DELEGATED DECISION

Item No.	Report of the Head of Development Management and Building Control	
Address:	123A CENTRAL AVENUE HAYES	
Development:	Alterations and extension to existing extension to create new end of terrace dwelling with associated amenity, parking and bin storage	
LBH Ref Nos:	78009/APP/2025/1540	
Drawing Nos:	Planning Statement dated May 2025 Impact Assessment by Sunlight Assessments UK Habitat Map reference MGC-000-L-490 Biodiversity Net Gain Assessment Issue 2.1 dated 25/06/2025 Preliminary Ecological Appraisal & Preliminary Roost Assessment Issue 2 dated 24/06/2025 1031-01_Rev01 Rev 8 1037-11 Rev 08 Flood Risk Assessment Version 1 dated June 2024 1037-12 Rev 01 1037-13 Rev 08 1037-14 Rev 08 1037-15 Rev 08 1037-16 Rev 08 1037-30 Rev 08 1037-35 Rev 08 1037-38 Rev 01 1037-39 Rev 01	
Date Plans received:	26-06-25	Date(s) of Amendments(s):
Date Application valid	26-06-25

Figure 1- Drawing 1037-11 Rev 08 compared to 3D visual images

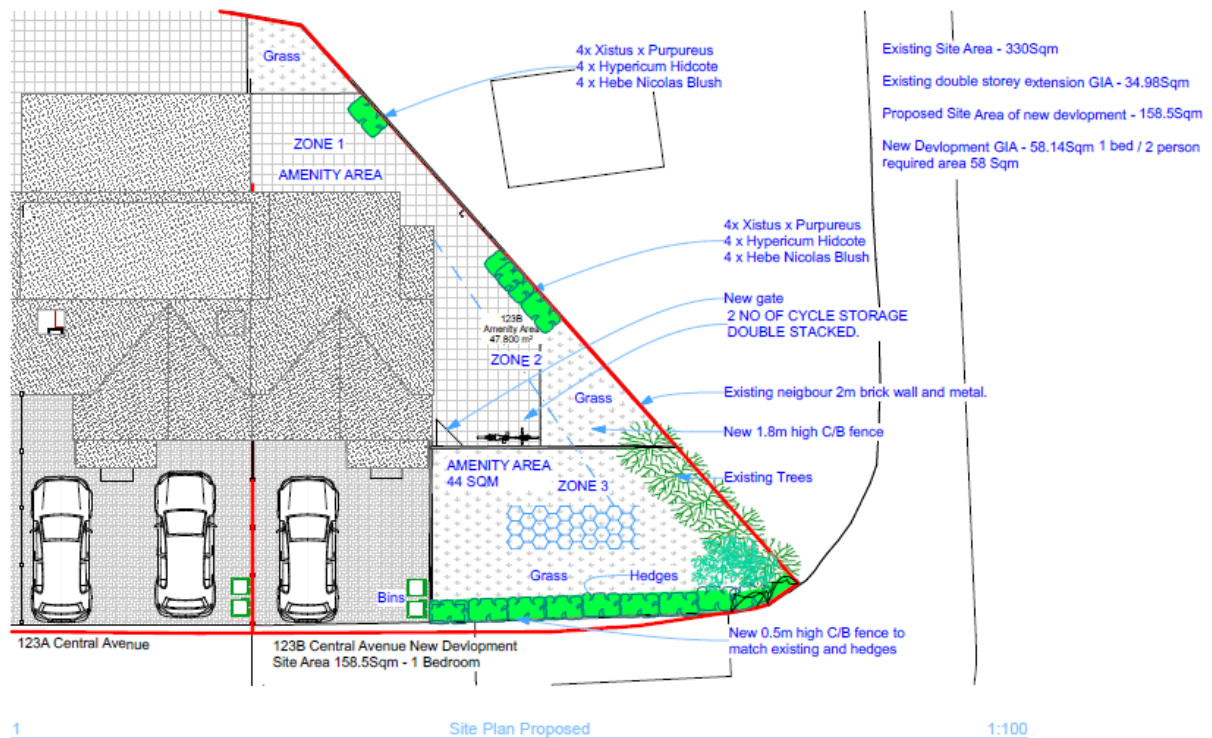
The London Plan Table 10.2 - Minimum Cycle Parking Standards requires that a minimum of 1.5no. cycle parking spaces should be provided. Drawing 1037-11 08 titled Proposed Site Plan shows the

provision of 2 cycle parking spaces within the middle section (zone 2) of the garden space. This is shown in close proximity to the an access gate which is considered acceptable. Should the application have been recommended for approval, a suitable condition would have been added securing the details of the cycle storage ensuring it was adequality secure and enclosed.

Figure 2- Screenshot of site plan showing angled site boundary, distances to side boundary and uncharacteristically sized rear garden.

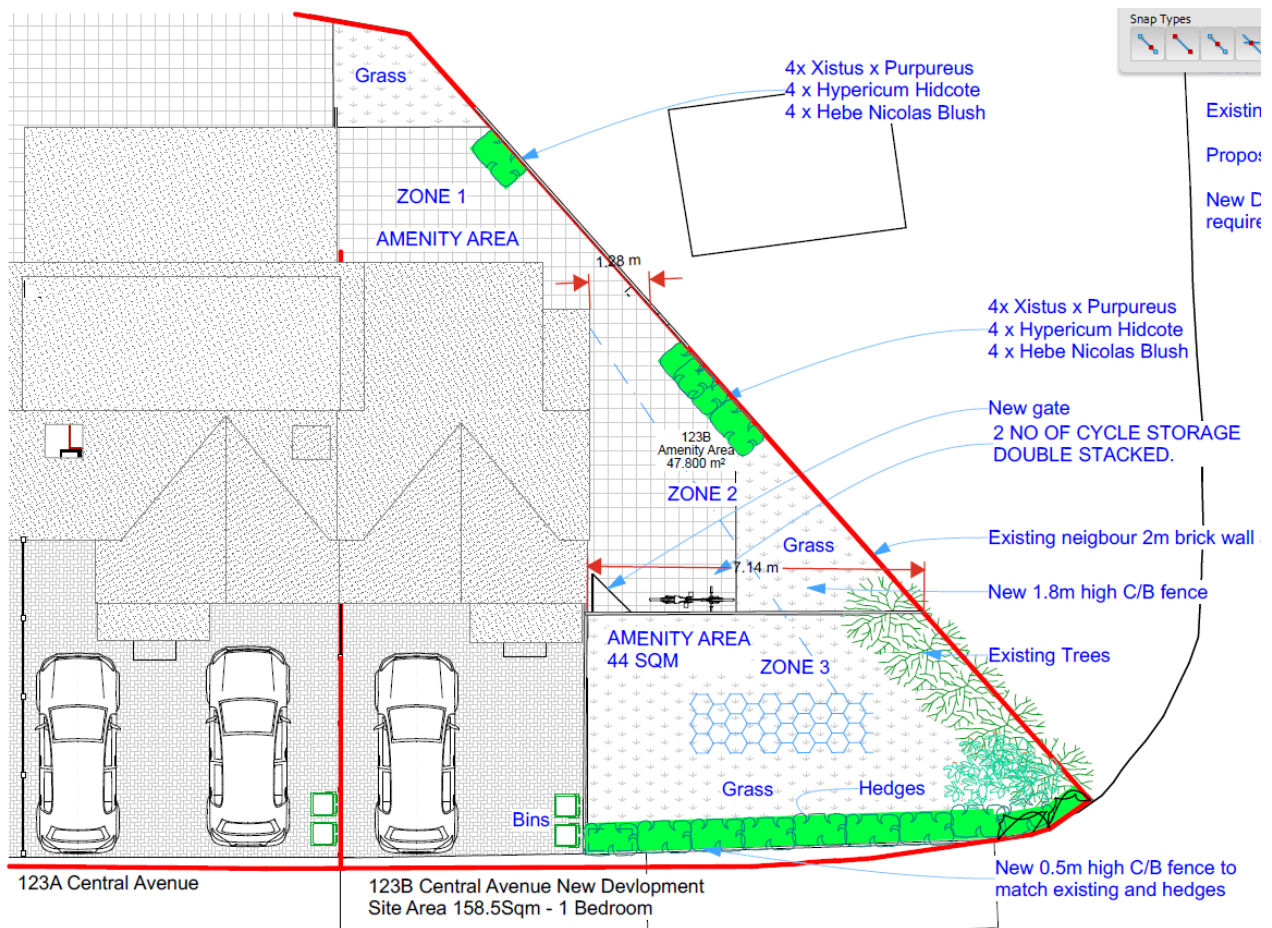
The proposed development has been slightly reduced in width from the previously refused scheme. It would measure approx. 5m in width, 6.9m in depth at both ground and first floor level (plus additional front porch), and measure approx. 7.4m in height characterised with a gable end roof form. The new dwelling would be in line with the front building line of 123A and include a front porch, front gable feature and would be finished in render. The development at its narrowest point within the plot would be set in from the side boundary by approx. 1.25m.

It is not considered that the reduction in width (approx. 2m) has sufficiently overcome the previous refusal reasons. The development would still harmfully enclose and infill the already diminished corner plot setting. It is not considered that the set in from the side boundary is adequate. As stated within the previous decision, the existing property at 123A Central Avenue benefits from a double storey side extension, this is set down from the main ridge and set back from the front elevation at first floor level appearing subordinate to the host dwelling. Whilst the applicant has stated that the development would be 'alterations and extensions' to this existing structure, the proposal would result in a substantially different structure that would no longer appear subordinate to the main dwelling.

The reduction in width of the new dwelling has resulting in a slightly larger side garden, however the rear garden would still appear uncharacteristically small which is uncommon within the immediate surrounding area. As explained within the previous decision, whilst surrounding rear gardens are on the smaller side, the proposed rear garden area would be extremely cramped within its plot appearing out of character with the prevailing design of the surrounding area. Along with this, the development would provide amenity space to the front of the site which is uncharacteristic within the surrounding area. Where side gardens do appear, these do not necessarily provide amenity space, rather they are a landscaped area.
